# Rezoning Transportation Analysis

Petition Number: Insert Zoning Petition #2021-062

Revision Log:	Date	Description
	05-27-2021	First Review (KP)
	06-24-2021	Second Review (KP)

SHEET NUMBER RZ-2.0

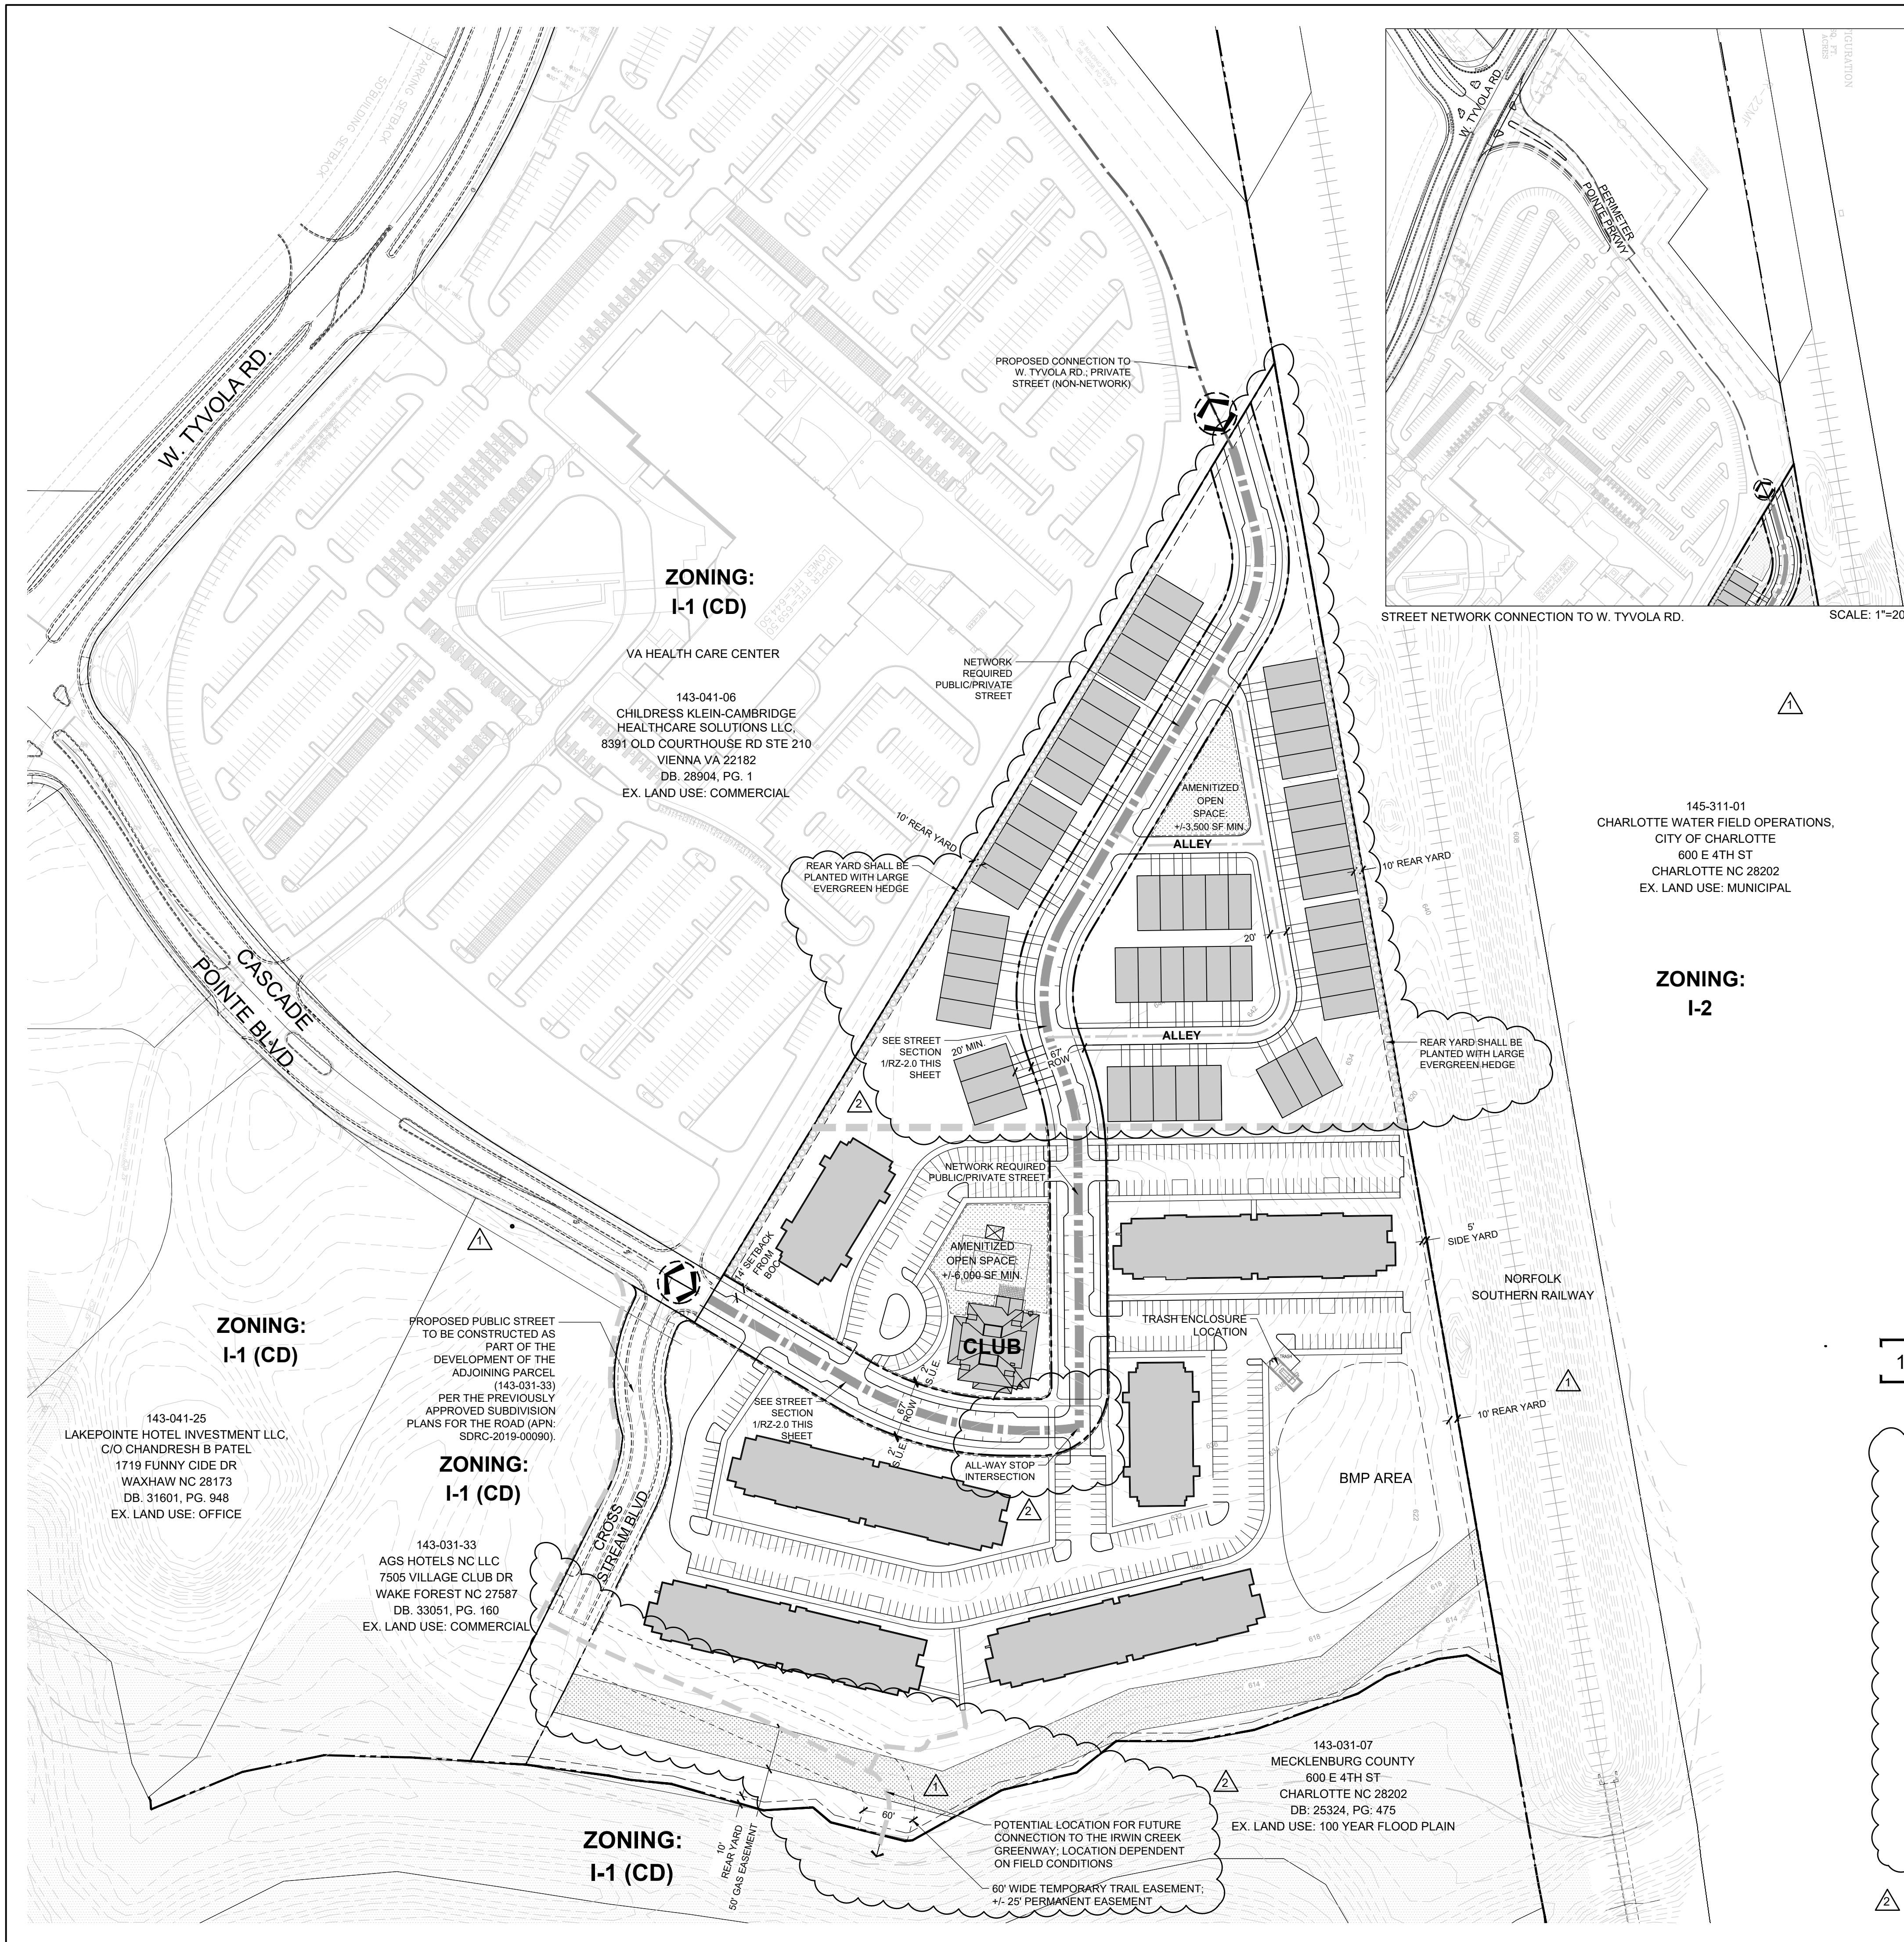
4. Revise the site plan and conditional notes by removing the parking lot access driveway located in the curve of the private street.

**Update to Comment as a Result of 06-14-2021 Site Plan:** Revise the site plan and conditional notes to commit to constructing this newly aligned roadway/driveway network as an all-way stop intersection with appropriate stop signs and stop bars. Additionally, commit to constructing ADA curb ramps to cross each leg of the intersection.

1 NETWORK REQUIRED PUBLIC/PRIVATE STREET SECTION NTS

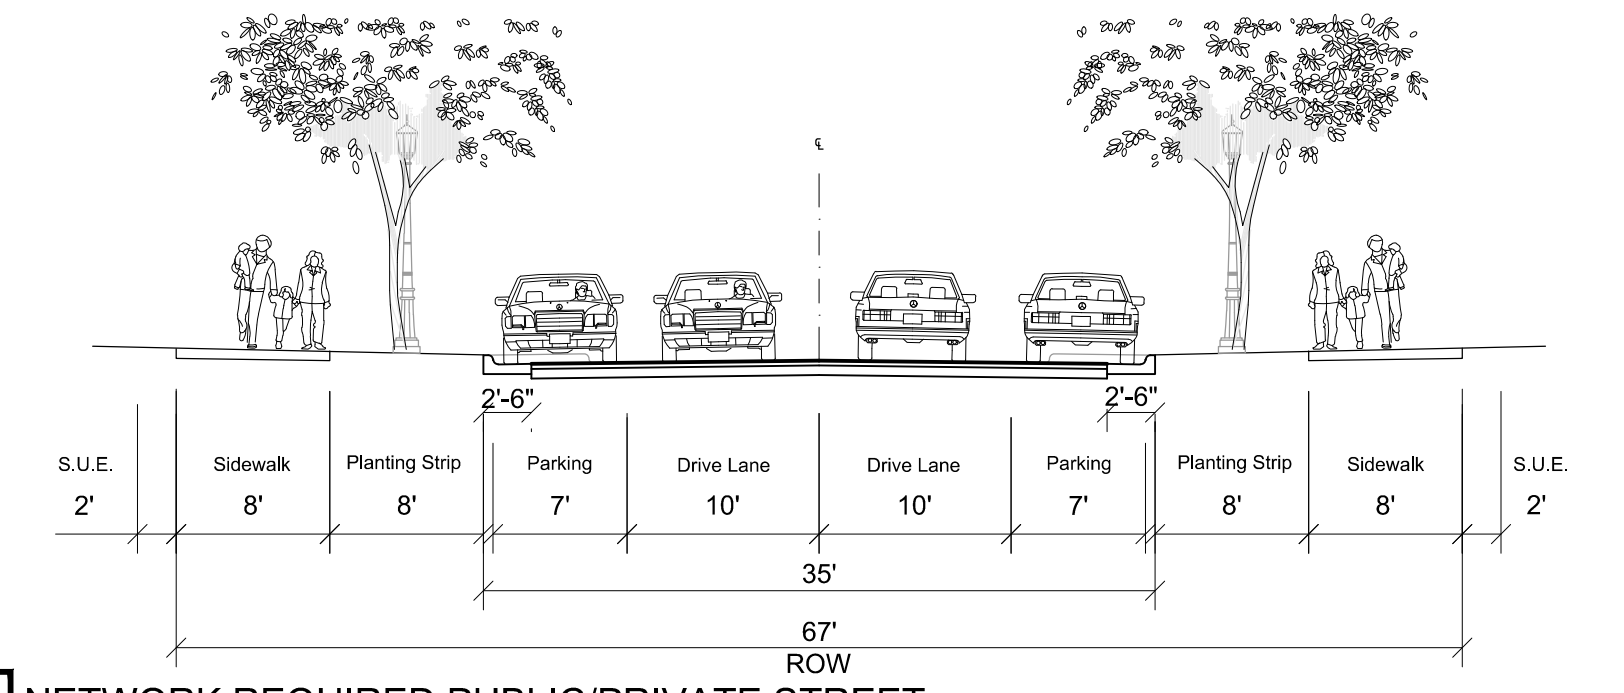
**Update to Comment as a Result of 06-14-2021 Site Plan:** Reference the CLDSM U-03A Local Residential Wide Section for the proposed public street cross section. Secondly, given the proposed density, 8-foot planting strips and 8-foot sidewalks are required along all public street frontages. Revise Cross Section 2 on sheet RZ-2 to incorporate an 8-foot sidewalk, if the street is intended to be public. Third, clearly label the proposed private and public streets and cross sections on the sheet RZ-2, and verify the conditional notes' accuracy and revise accordingly referencing public or private streets, specifically note 3.a. Streets and cross sections shall not be labeled Public/Private and there will be no ambiguity associated with the limits of the public and private street(s) network.

Limits of Public and Private streets need to be determined prior to rezoning approval.
